REQUEST

Current Zoning: NC (neighborhood center)
 Proposed Zoning: CG(CD) (general commercial, conditional)

Approximately 0.434 acres located along the east side of Beatties Ford Road, south of Holly Street, and north of Dr Webber Avenue.

The petition proposes to allow all uses permitted by-right and under prescribed conditions in the general commercial zoning district on a parcel that previously hosted commercial uses.

**FIFTH THIRD BANK  
REZONING PETITION NO. 2023-XXX  
10/19/2023**

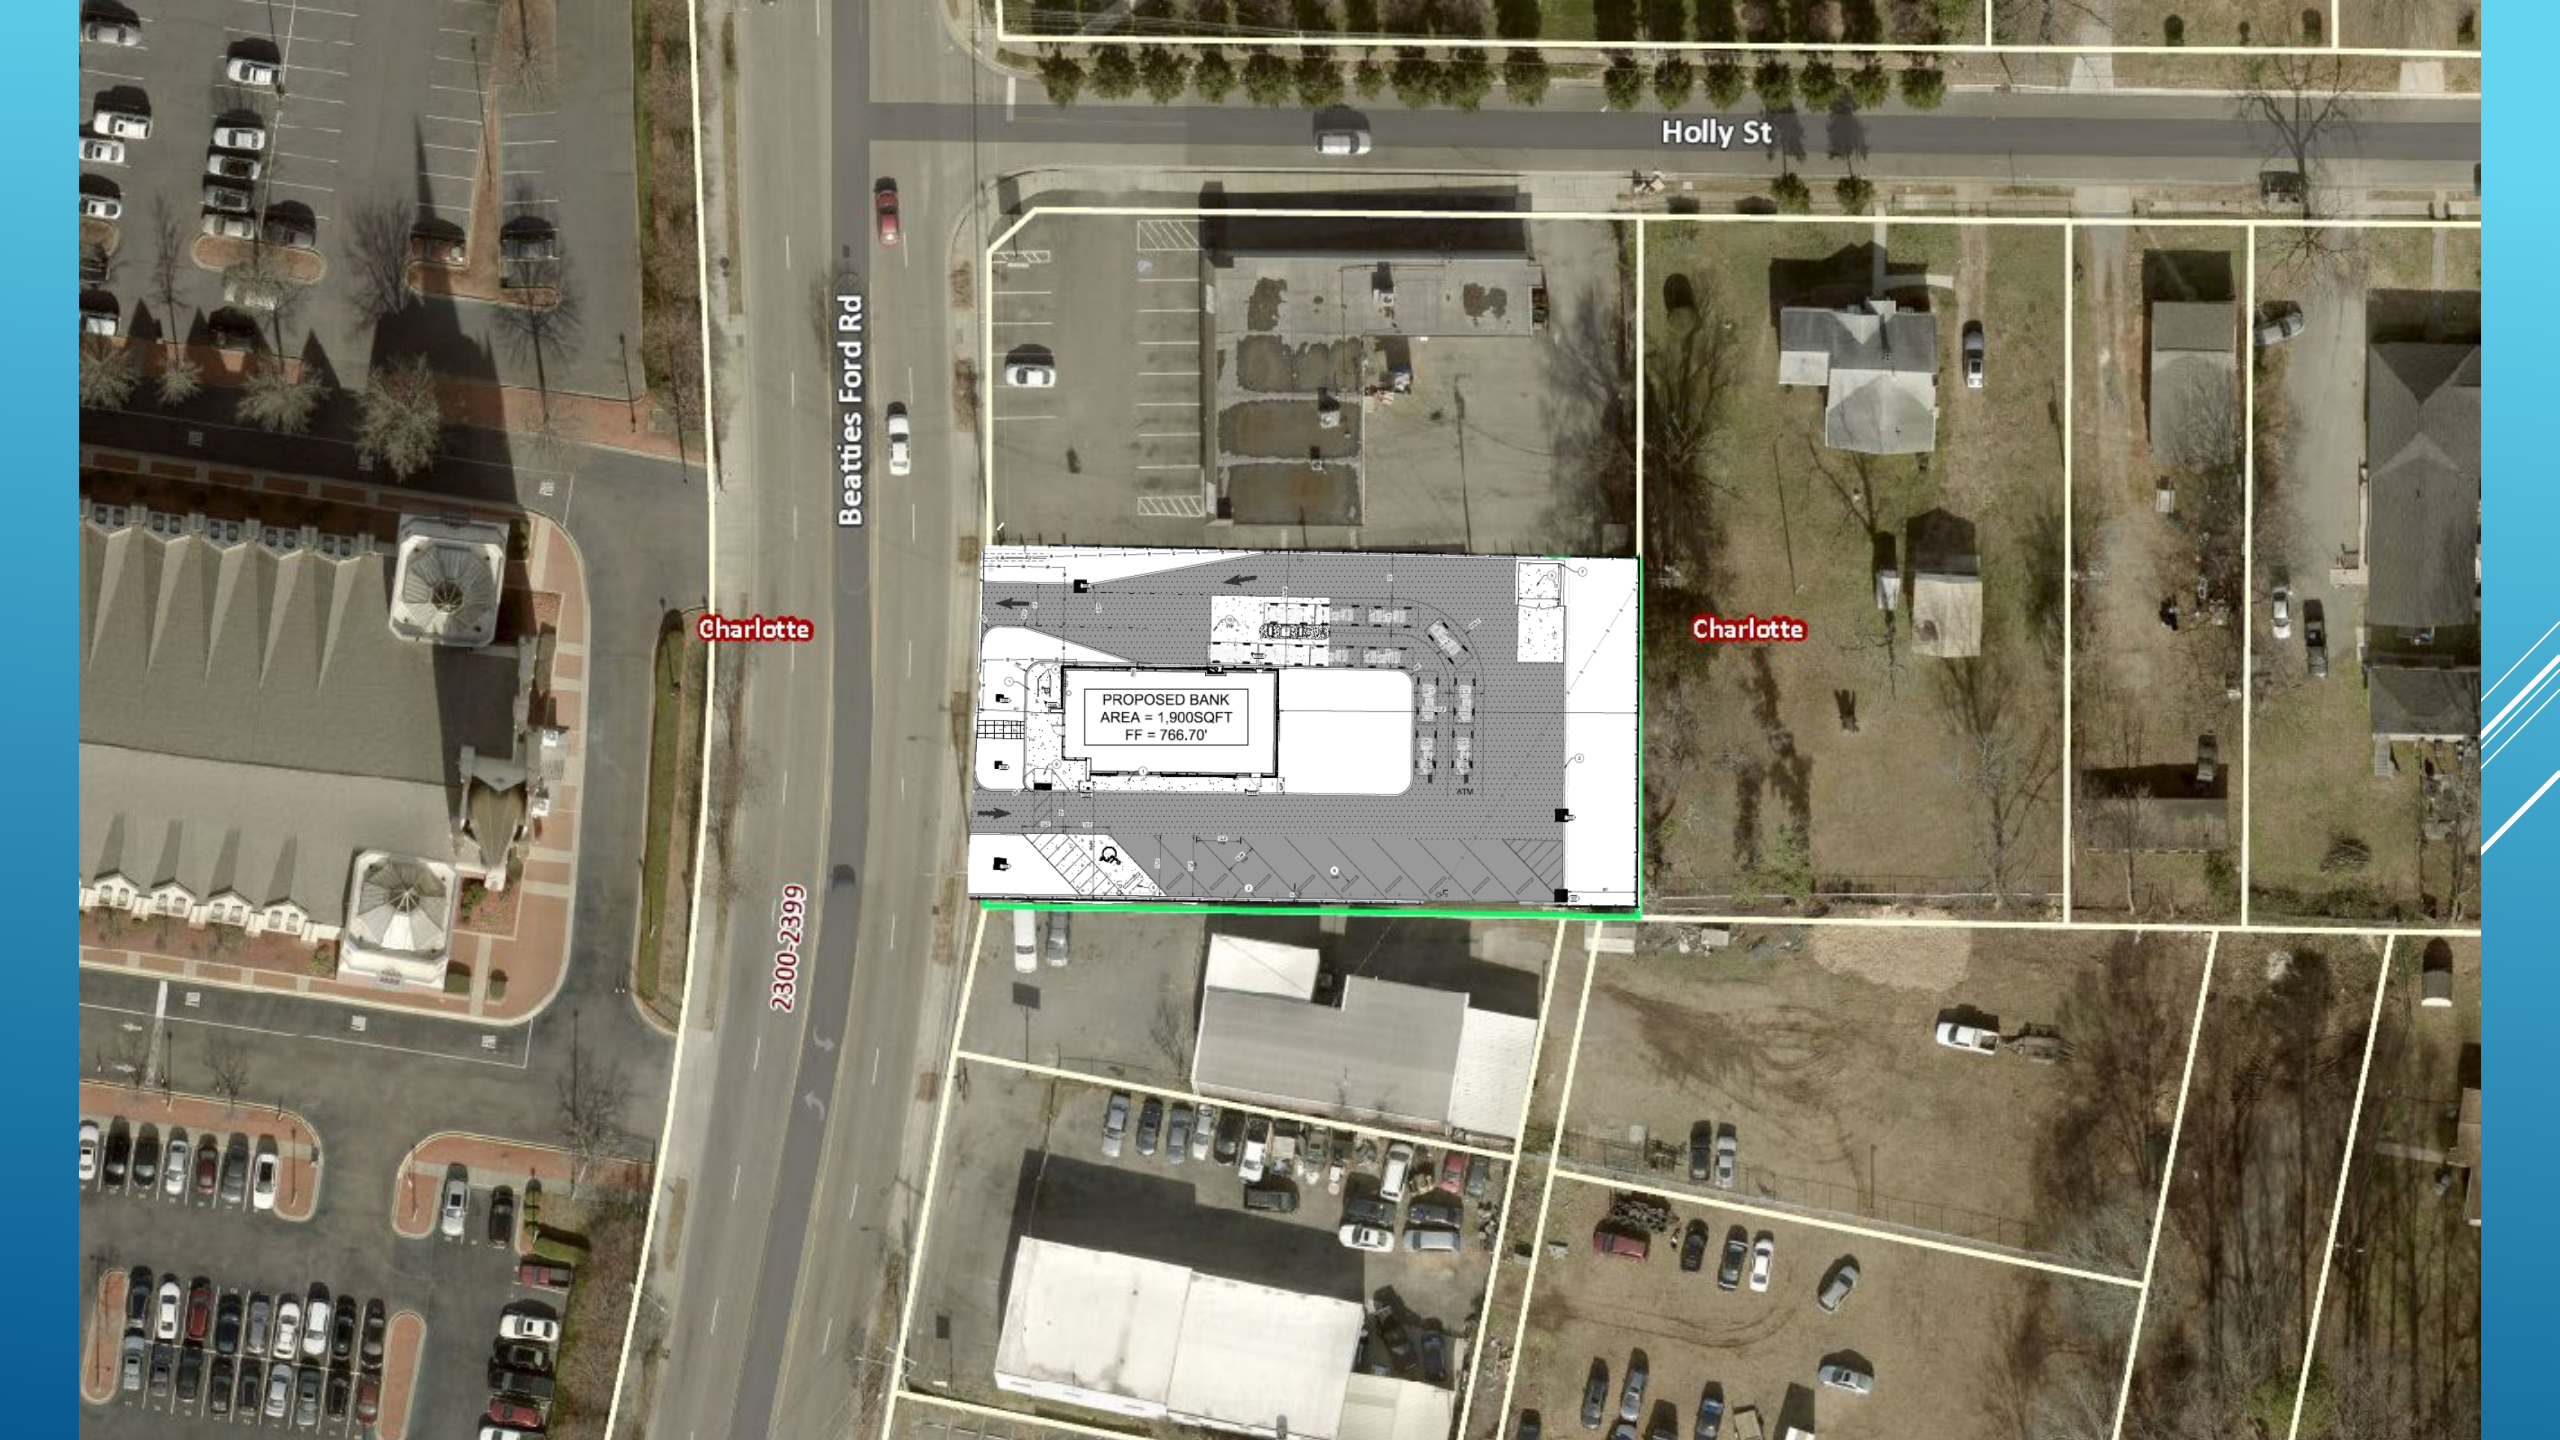
1. Specify where the drive-through windows would be placed.
 2. Specify if the elimination of a travel lane in the front of the building could allow for the development of a plaza space or green area.
-
